**Observation on EIS in relation to inadequate baseline monitoring on air quality compliance in the SID for the proposed development by Indaver NV trading as Indaver Ireland for a Resource Recovery Centre ( including a waste - to -energy facility ) at Ringaskiddy**

ABP Case Reference **PA004. 318802**

**Observation on Environmental Impact Statement (EIS) – Air Quality Compliance**

Figure 8.4 Cork Airport Windrose 2021 -2025

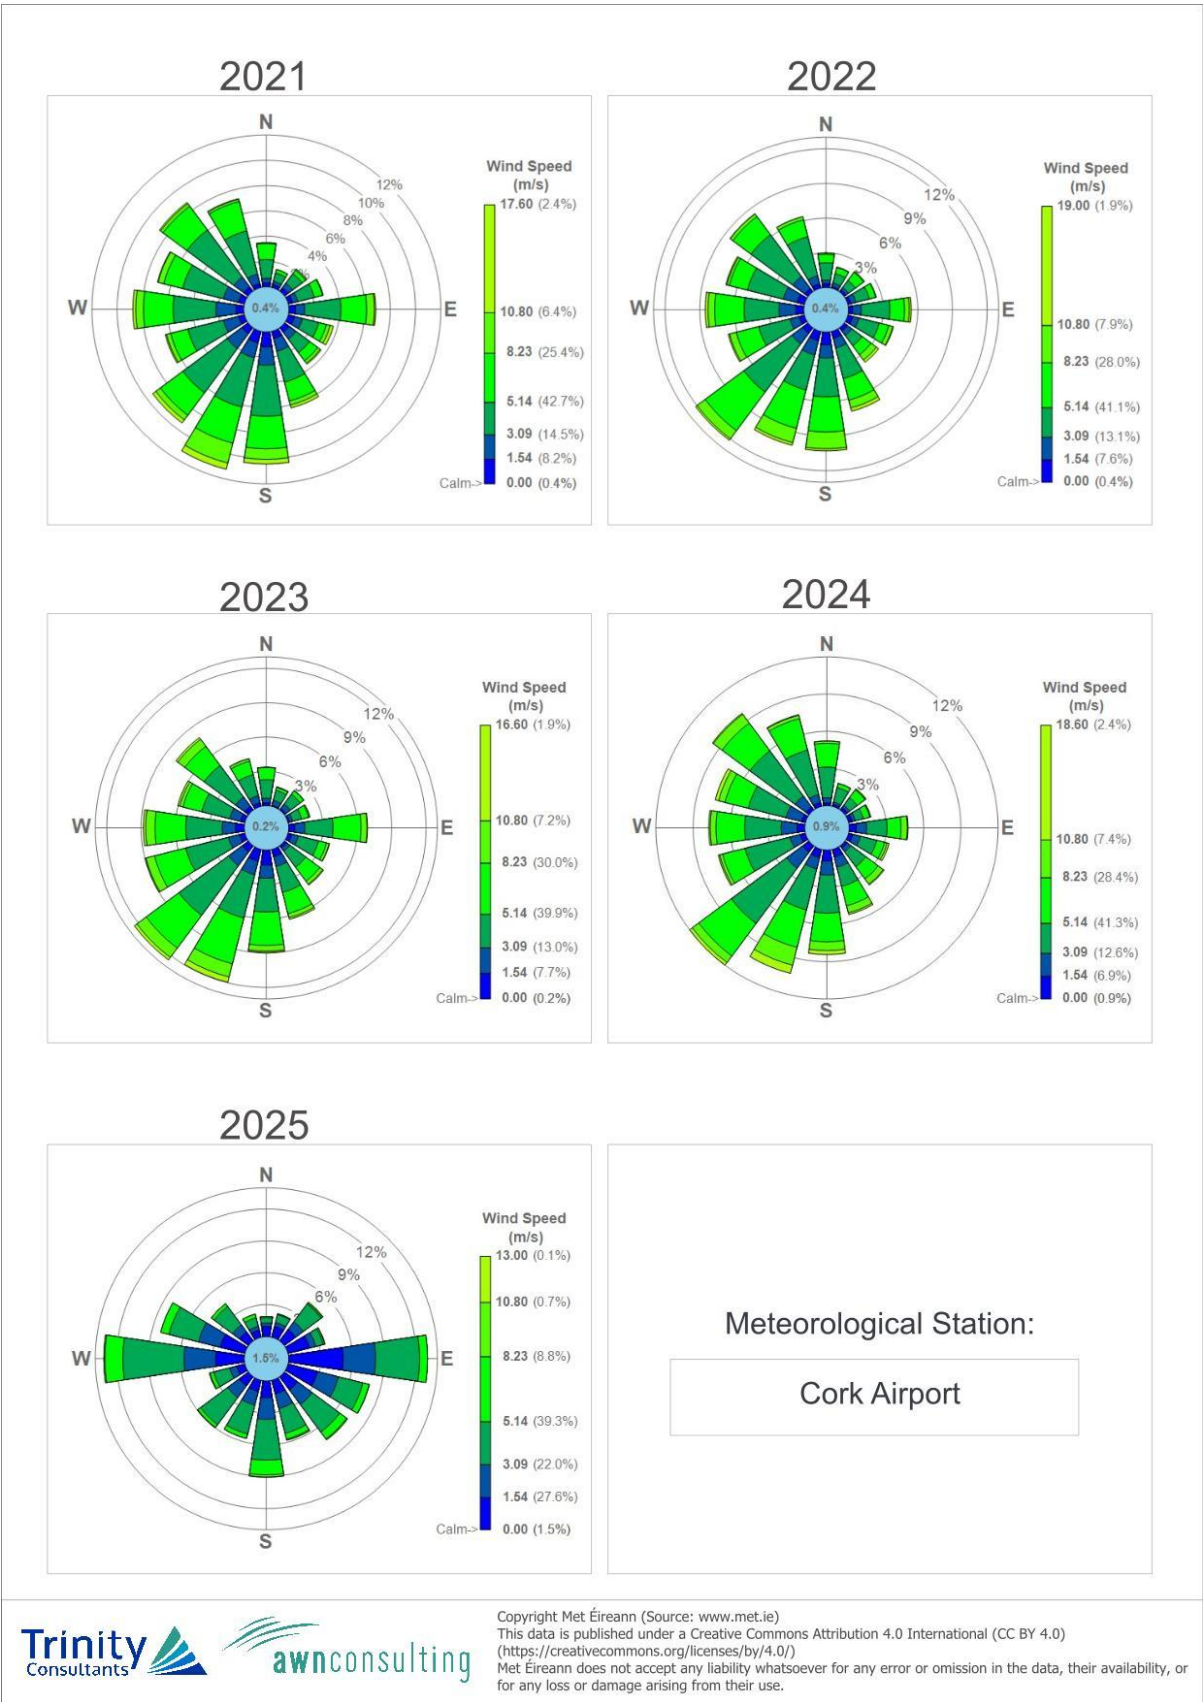
**Issue:** Dispersion modelling in Chapter 8 relies on meteorological data from Cork Airport (~15 km northeast), rather than Roches Point lighthouse (~5 km southeast, at the harbour entrance), as explicitly recommended by An Coimisiún Pleanála in prior assessments (e.g., 2018 Board Order PA0045 conditions for site-specific meteorology). This distant inland source fails to capture the unique microclimatic features of the estuarine,

maritime location—such as sea breezes, tidal influences on humidity, and complex wind channelling over Cork Harbour—which can alter plume dispersion, ground-level concentrations, and deposition patterns for pollutants like PM and dioxins.

**Non-Compliance:** Contradicts EPA guidance (AG4:2012) and AAQD Annex III for "local" meteorological inputs in coastal/industrial EIAs to ensure accurate modelling (e.g., AERMOD/CALPUFF simulations). Roches Point data better represents prevailing southerly winds and inversion risks, essential for assessing impacts on downwind receptors (e.g., Haulbowline, Cobh) and Natura sites. Using airport data risks over- or under-predicting concentrations by over 20% in estuarine settings, per peer-reviewed studies on harbour microclimates (e.g., Atmospheric Environment, 2019).

Figure 8.8 Ambient Air Quality Monitoring Locations - Ringaskiddy

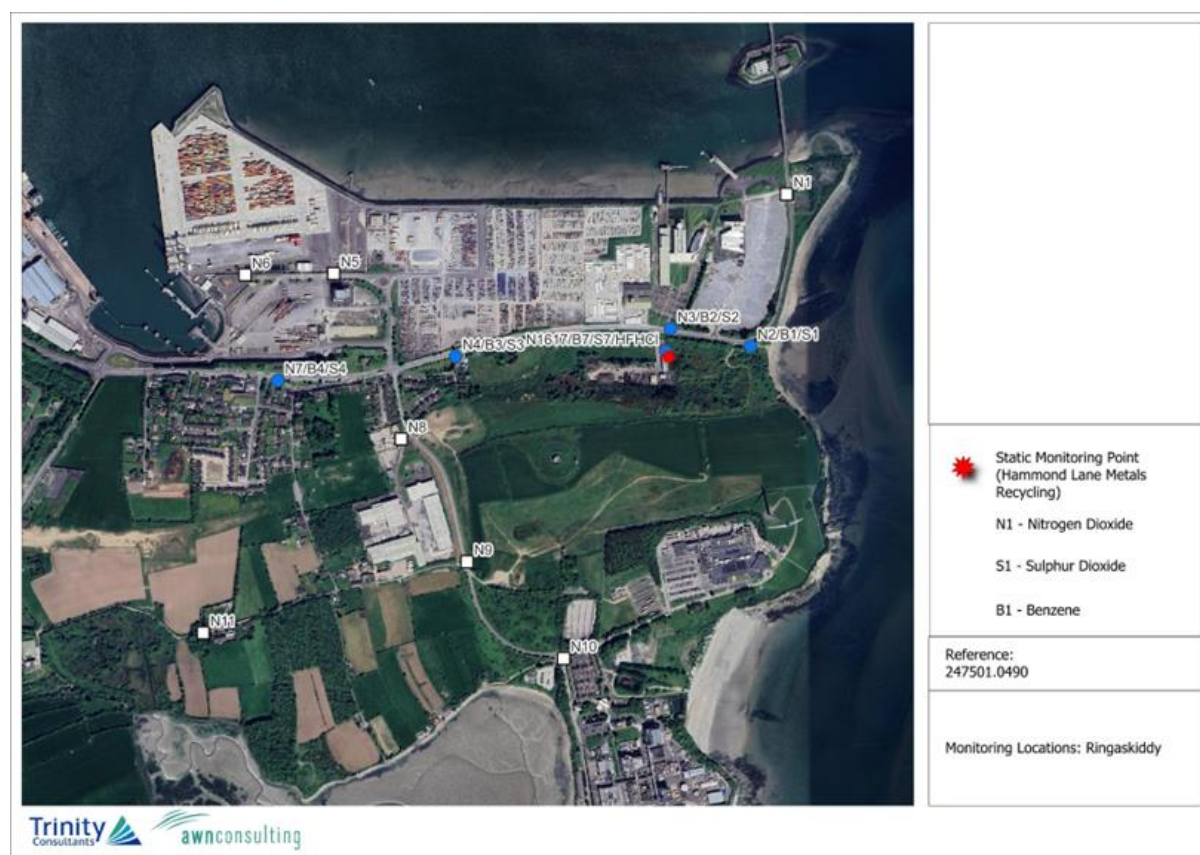
**Issue:** Continuous PM10/PM2.5 monitoring is limited to one site (Hammond Lane Metals Recycling, next to the proposed facility, coordinates  $\sim 178500\text{E}, 70000\text{N}$ ), justified in the EIS as "operational efficiency and representativeness near emission sources." This site recorded baseline PM10:  $9.4 \mu\text{g}/\text{m}^3$  and PM2.5:  $5.7 \mu\text{g}/\text{m}^3$  (2024-2025 data), but the EIS implies broader coverage across the  $\sim 10$  km study area (e.g., Monkstown, Cobh, Passage West) through figures depicting multiple markers. In reality, passive diffusion tubes (e.g., for NO<sub>2</sub> at N1-N16, SO<sub>2</sub>/benzene at S1-S7/B1-B7) dominate elsewhere, with no added continuous PM sites—making the assessment unrepresentative of downwind/residential gradients or harbour dispersion.

**Non-Compliance:** Violates AAQD Annex I (representative monitoring in agglomerations  $>250,000$  inhabitants, applicable to Cork conurbation) and Irish EPA guidance (AG4:2012) for multi-point baselines in heterogeneous terrains. The confinement to Hammond Lane (an industrial yard, elevated  $\sim 5$  m) biases results toward source-proximate levels, underestimating exposure at sensitive receptors like Martello Park residences (N4) or Loughbeg school (N11).

**Natura Sites Omission:** Locations do not include direct monitoring within or adjacent to protected areas, such as the Cork Harbour SPA (encompassing Haulbowline, Spike Island, and eastern harbour channels) or Great Island Channel SAC (marine/coastal habitats  $\sim 1-2$  km southeast). While terrestrial sites extend to Cobh Promenade (N14/S6/B6, harborside) and Monkstown (N12/S5/B5), no PM-specific points target SAC/SPA boundaries, ignoring potential acidifying/eutrophying deposition (Habitats Directive 92/43/EEC, Article 6). This is accurate based on EIS Figures 8.8-8.9, which focus on urban/industrial nodes without marine extensions.
